Lead Local Flood Authority
Post Point CHN 215
Hertfordshire County Council
County Hall, Pegs Lane
HERTFORD SG13 8DN

Date 15 April 2021

**RE: Surface Water Advisory Service – Hertfordshire Constabulary HQ,
Stanborough Road, Welwyn Garden City, AL8 6XF**

Catchment 1 - Drains to Outfall A unrestricted
 Catchment 2 - Drains to Outfall B unrestricted
 Catchment 3 - Drains to Outfall B restricted

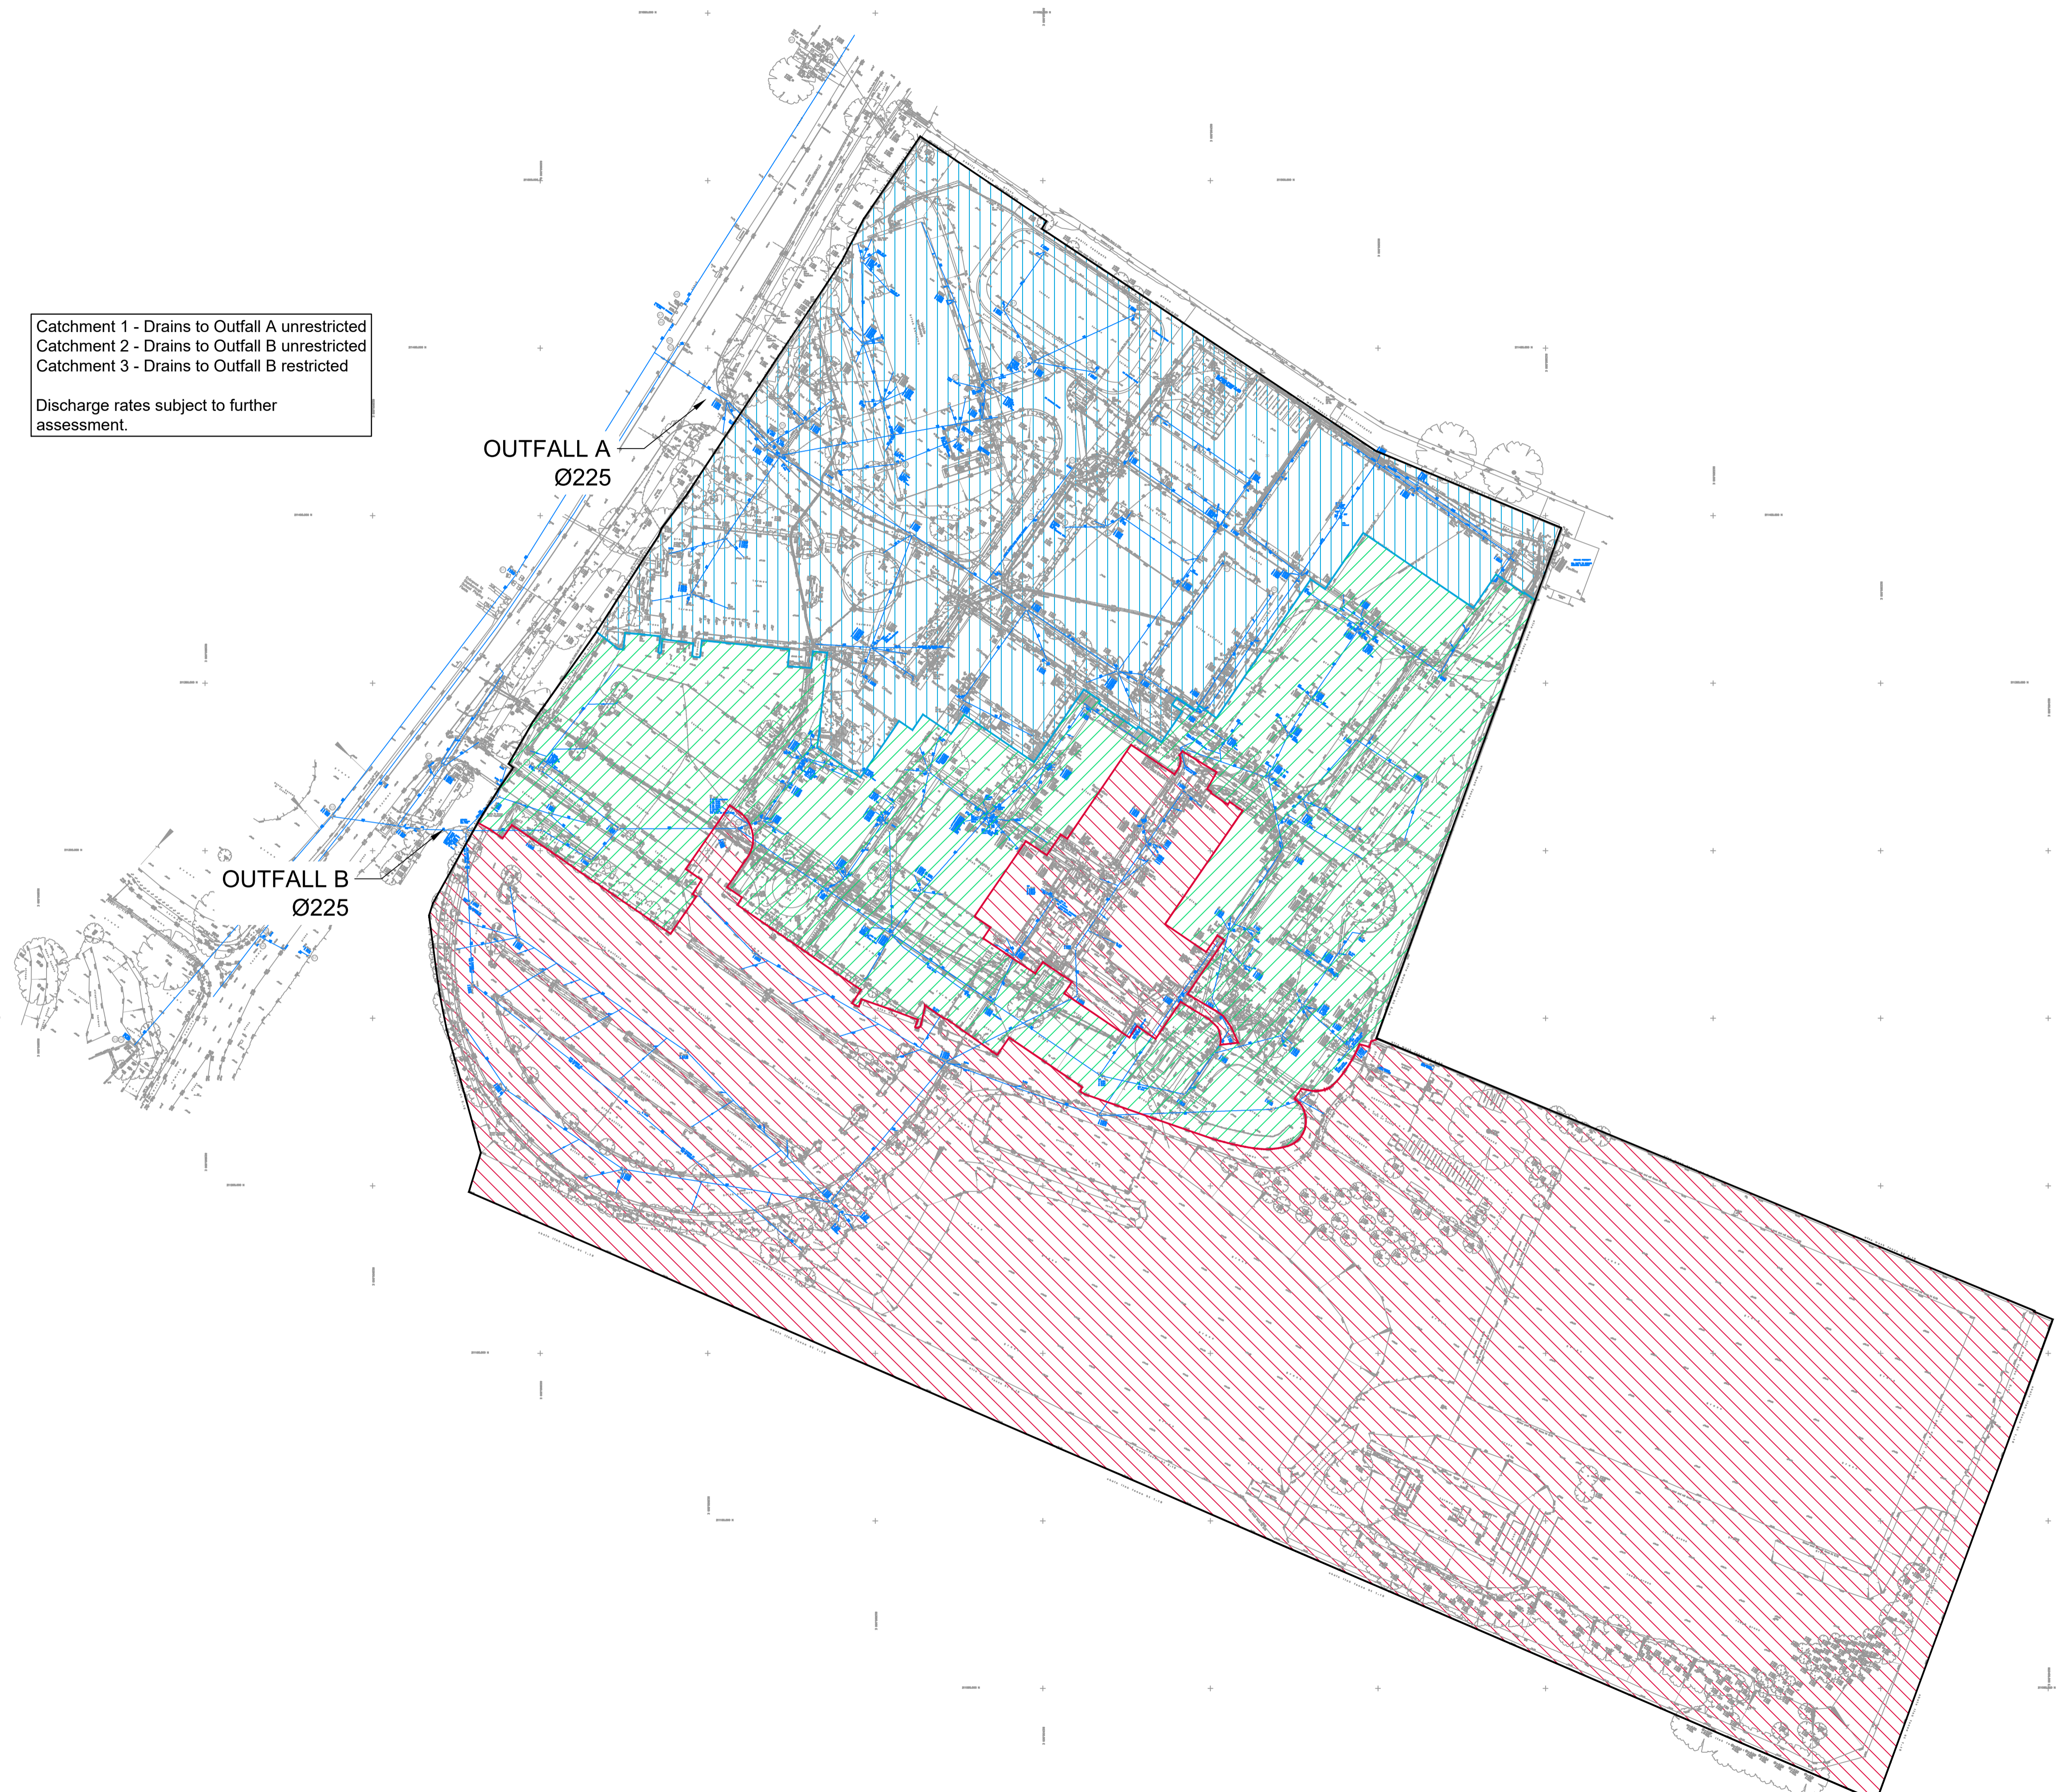
We note that whilst on site we saw no evidence of a restriction device on the outlet pipe located in the existing pond feature. As the applicant intends to use this feature to discharge the surface water run-off for the development, we would expect the overall discharge to be restricted and the location of the restriction device to be highlighted. We would expect the applicant to restrict the discharge rate of the proposed development down to the Qbar for the site.

We note that the discharge goes through a Thames Water Surface Water sewer before finally discharging into the Stanborough Lakes. We would therefore advise the applicant

that a pre-planning enquiry should be submitted to Thames Water to ensure that they accept the additional discharge into their asset.

Figure 9 - Typical underground storage

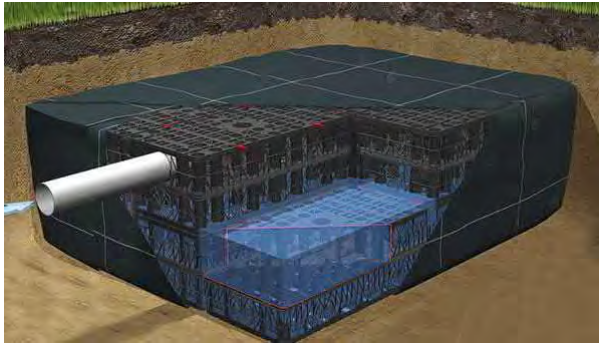
We note the inclusion of tanked storage as a means of providing additional attenuation volumes. Whilst in principle this is acceptable, we would expect to see the applicant provide adequate justification that all other methods of storage have been assessed.
